From: Andrew Wood
Sent: 17 May 2019 13:00
To: Planning.Responses
Subject: FW: planning application FG/220/18/PL New house in garden of Elm Lodge, Tamarisk Way, Ferring, BN12 5ER

From: [REDACTED]
Sent: 03 March 2019 11:28
To: Andrew Wood
Subject: planning application FG/220/18/PL New house in garden of Elm Lodge, Tamarisk Way, Ferring, BN12 5ER

PROPOSED ROOF PLAN AND
PROPOSED ELEVATIONS

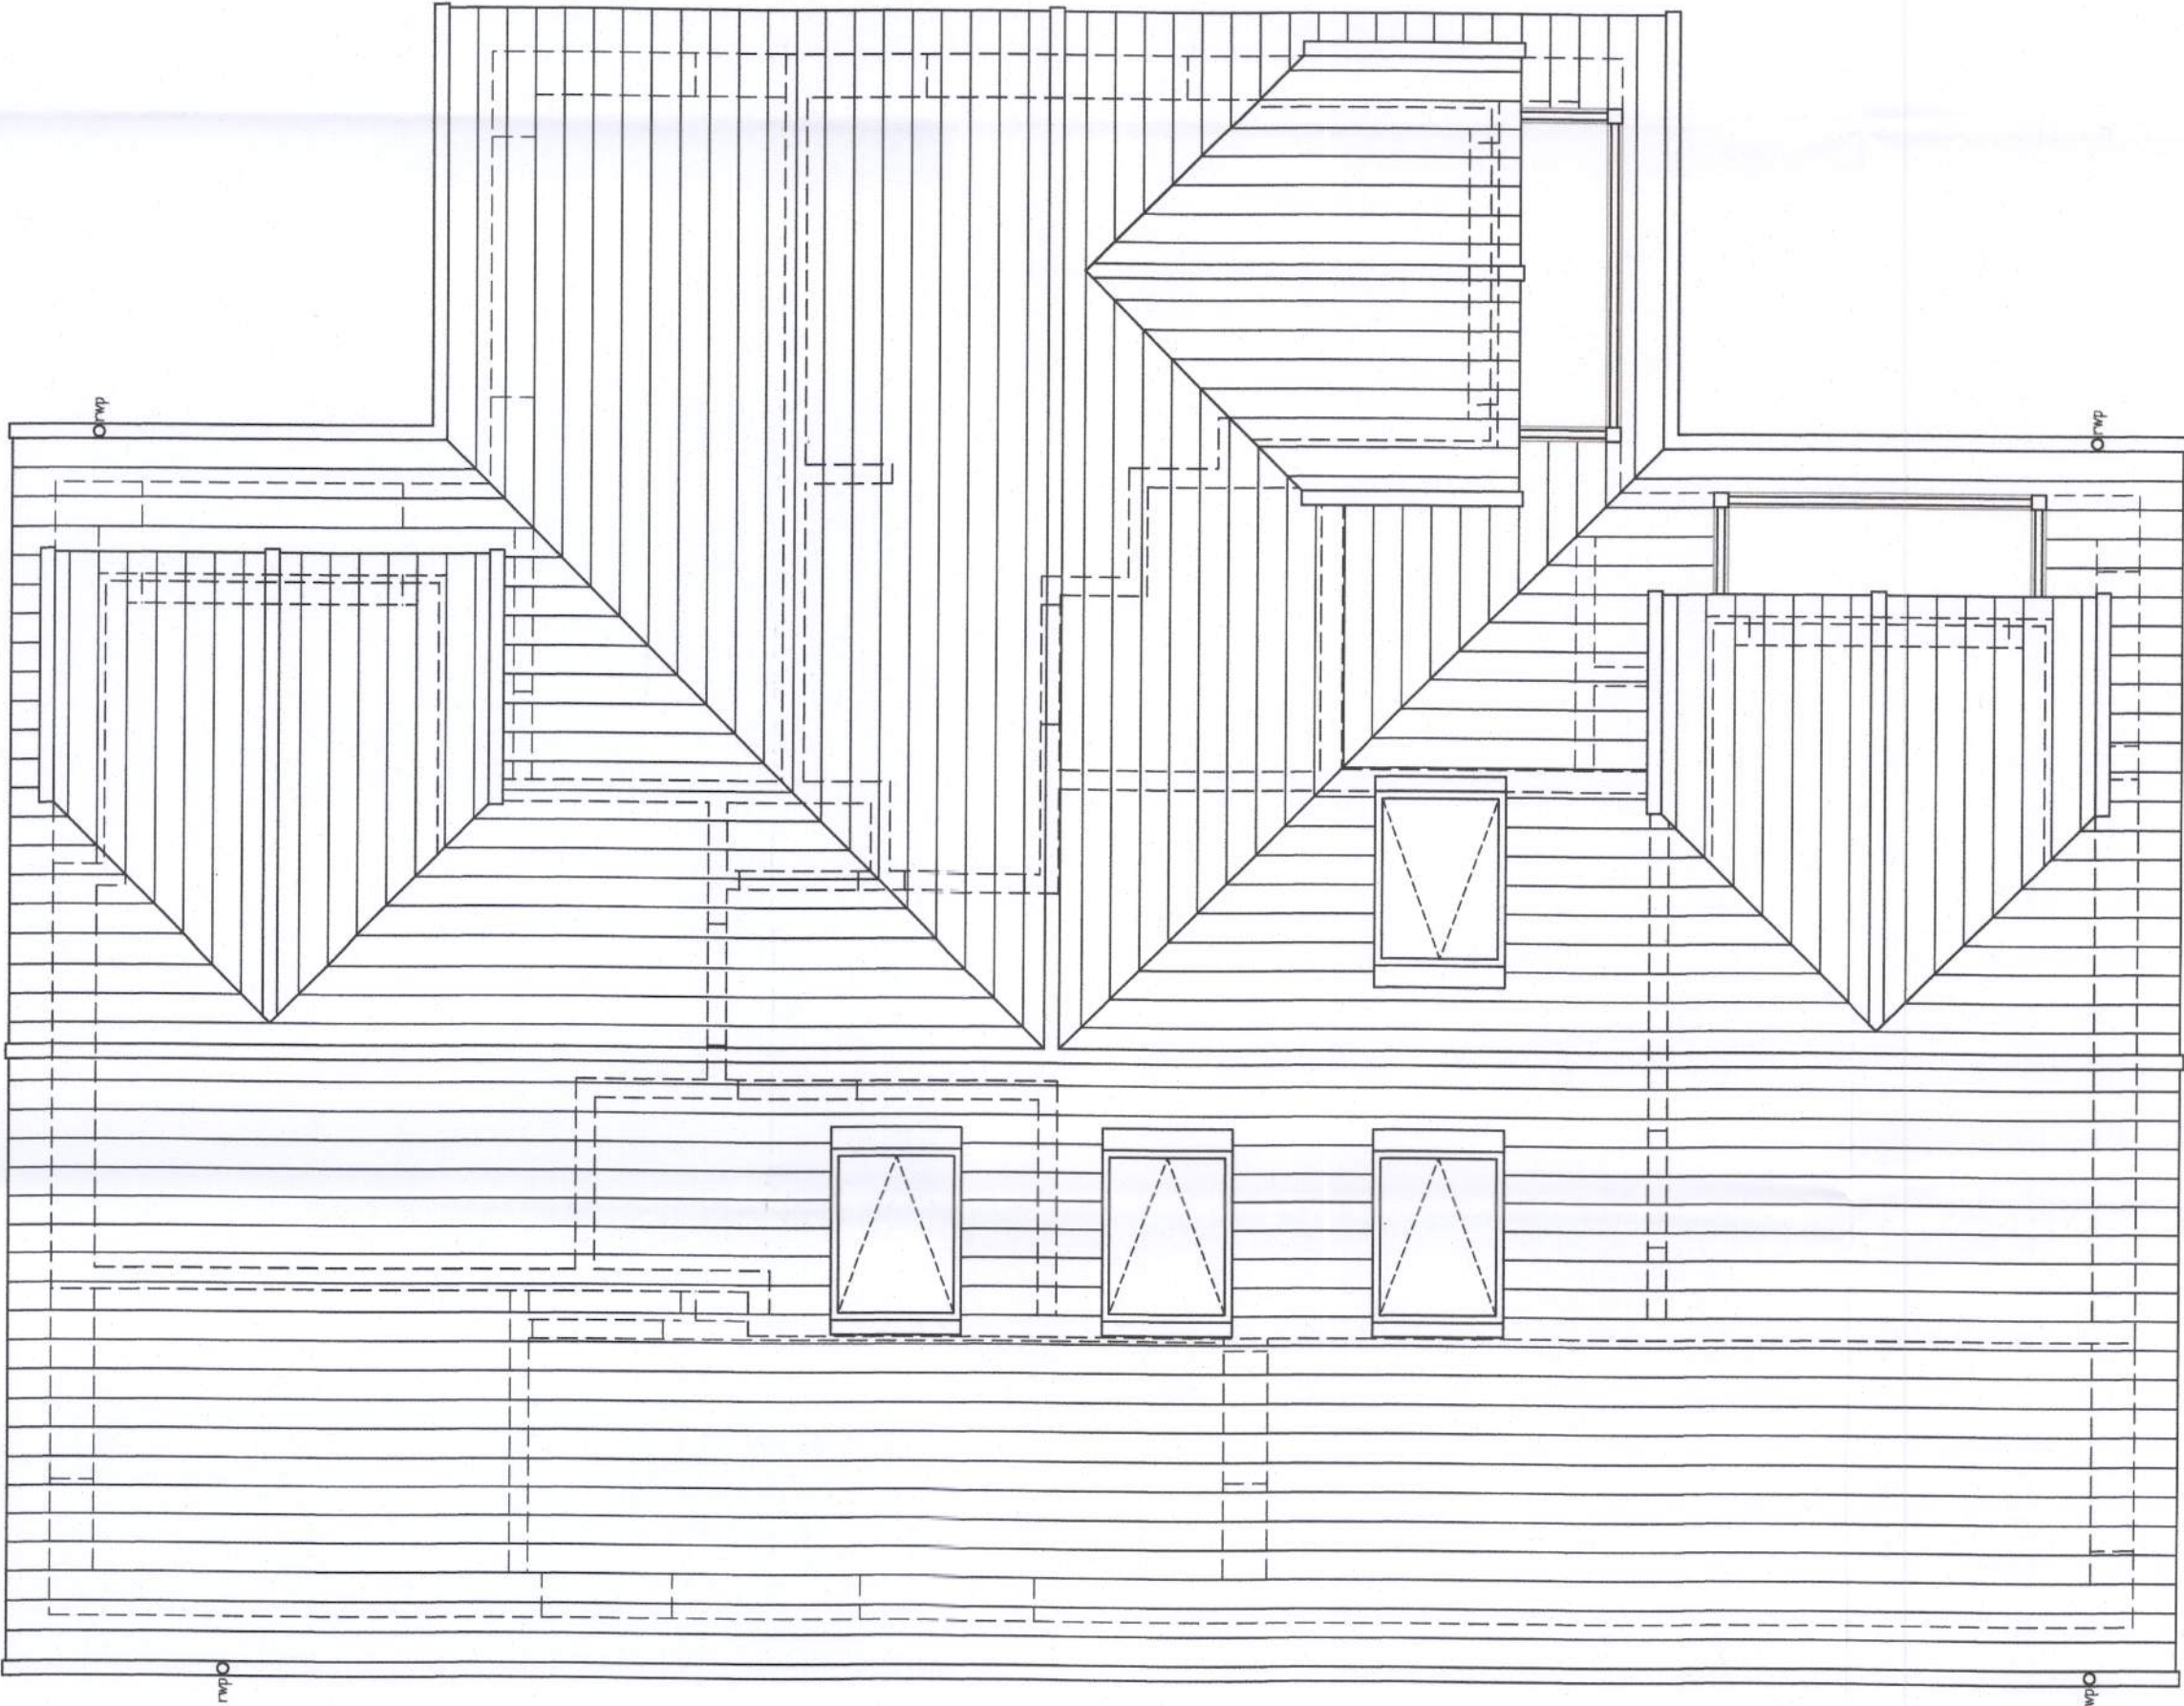
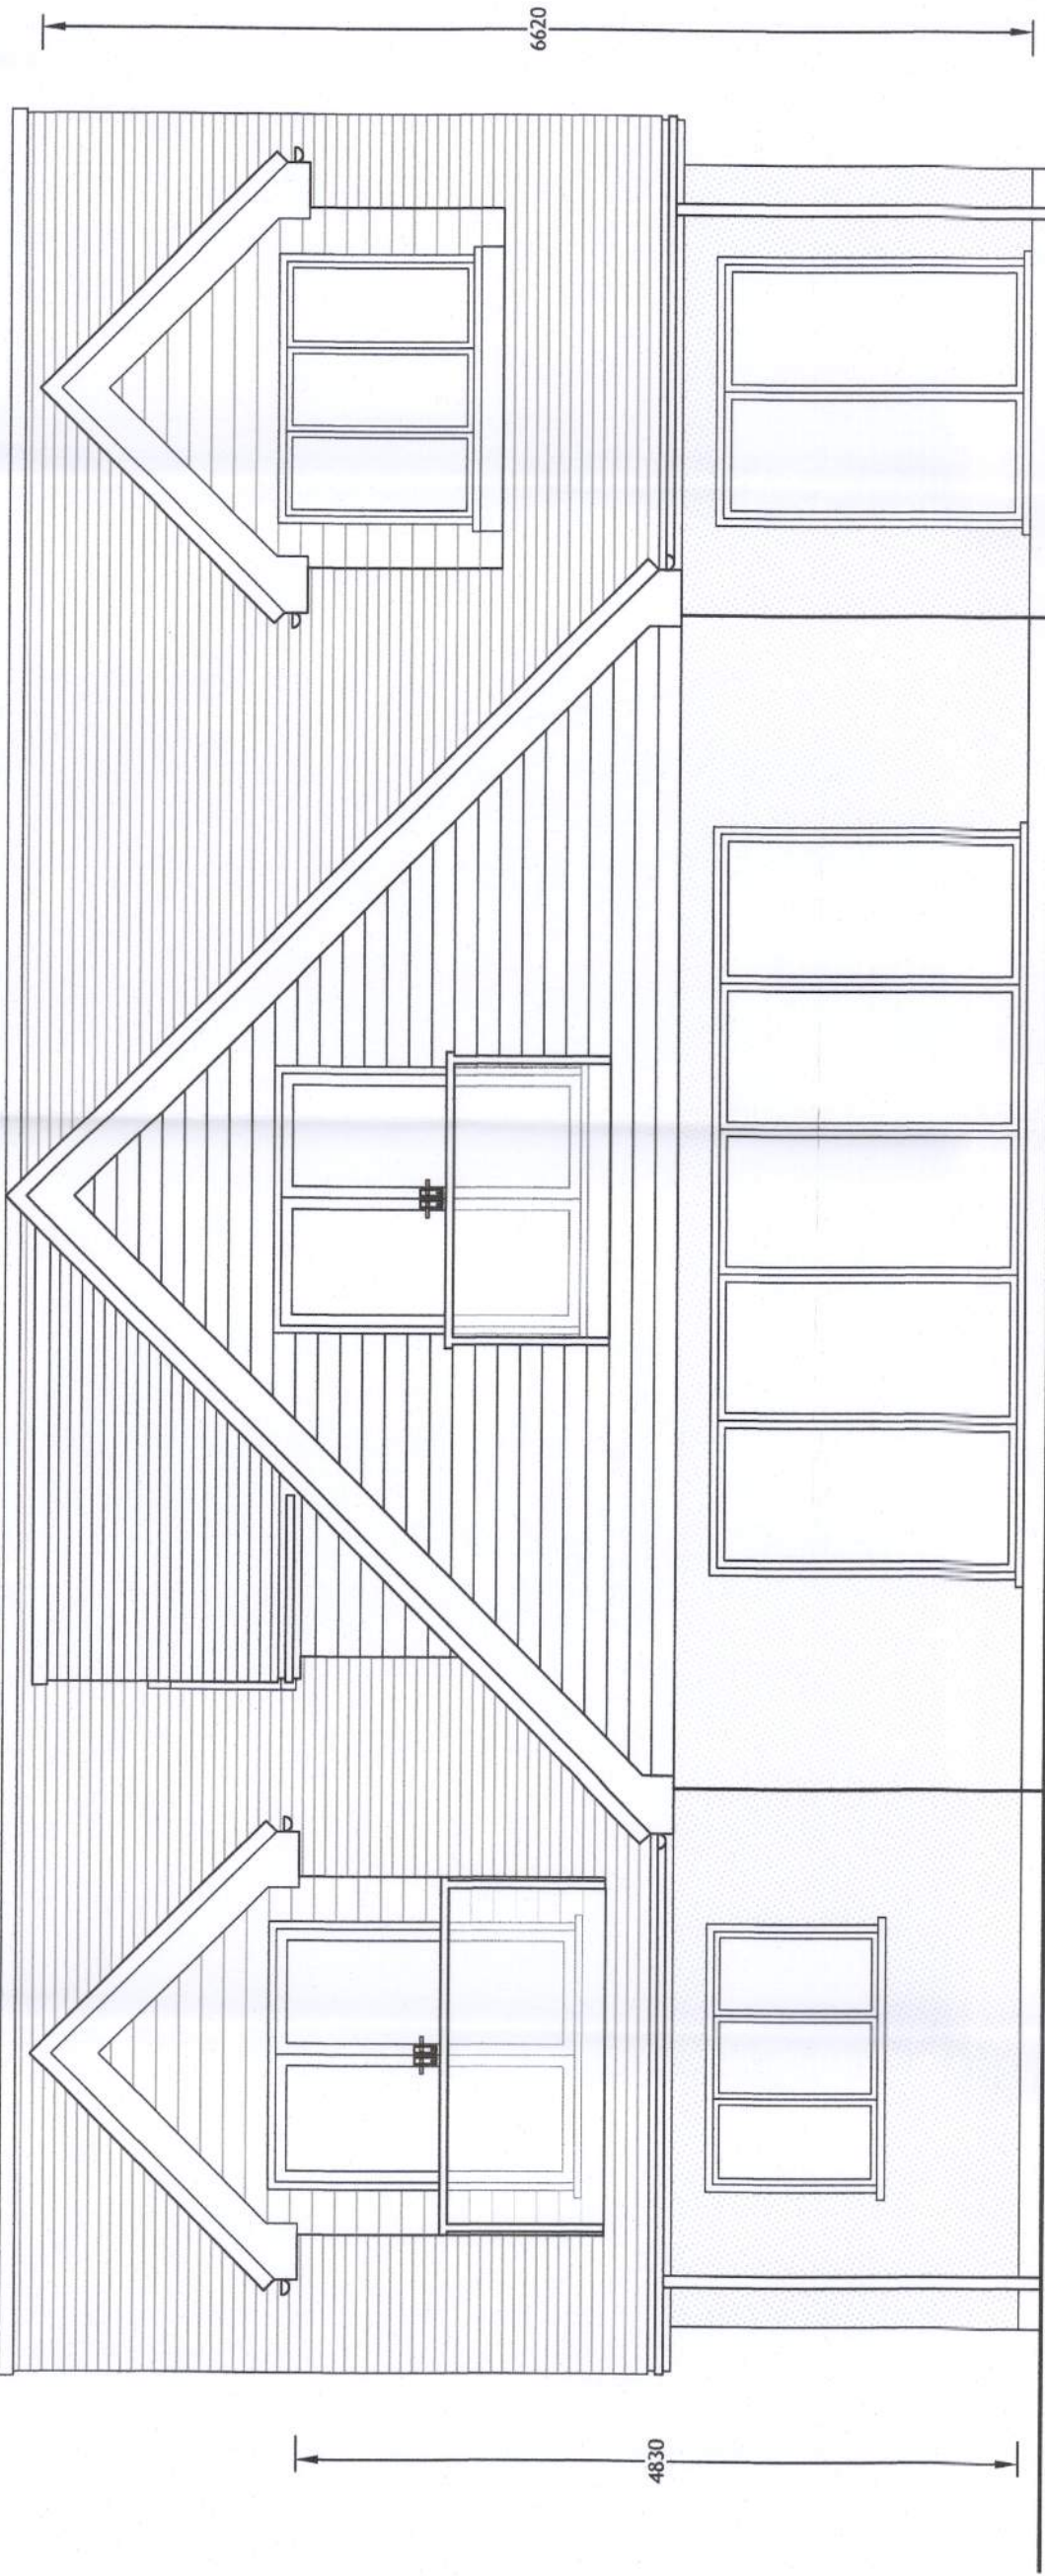
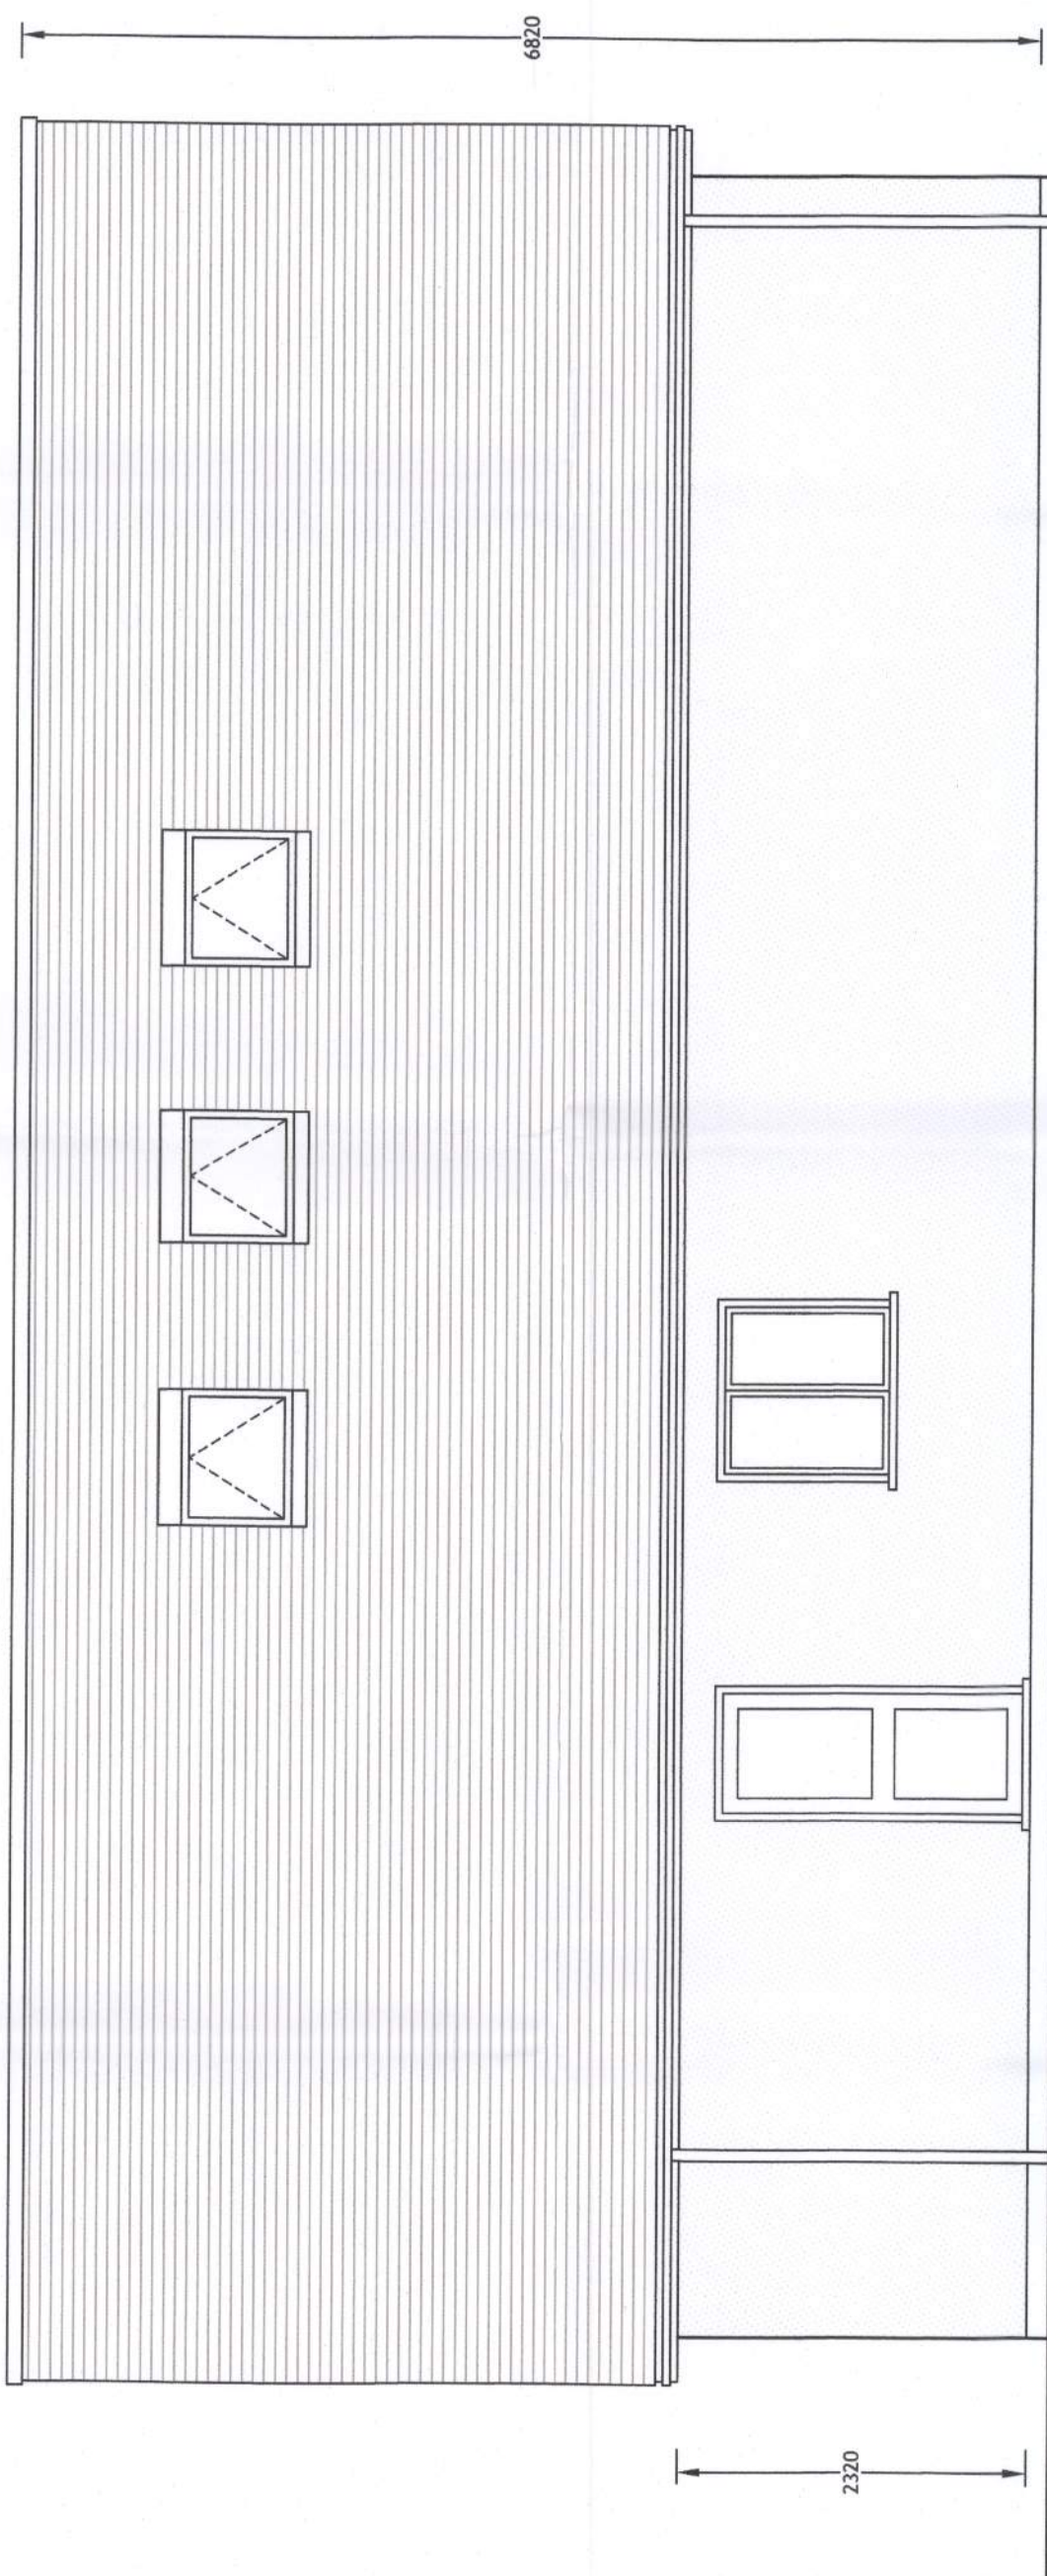
The proposed house plans call for 3 full length balcony windows on the first floor, 2 of which will look down directly into habitable areas and gardens of Magalia (one of these windows fully covers the entire 1st floor gable). We would point out that this is in addition to a third window which is to be installed in Elm Lodge and which is in fact less than the recommended distance from Magalia (see discussions held at a site visit from a member of the Arun Planning Dept. in November last year). This presents an excessive and unacceptable intrusion of privacy and we believe this to be contrary to the requirements of the Arun Local plan as detailed above

The ‘post- modern’ style of the proposed house and alterations to Elm Lodge are highly suitable for the urban Home Counties, but are completely out of character and sympathy with the houses in and around Tamarisk Way and along Sea Lane. The use of cladding, blue slate tiles and grey windows bears no resemblance to any building materials used in the vicinity of Tamarisk Way and would stand out like a ‘sore thumb’.
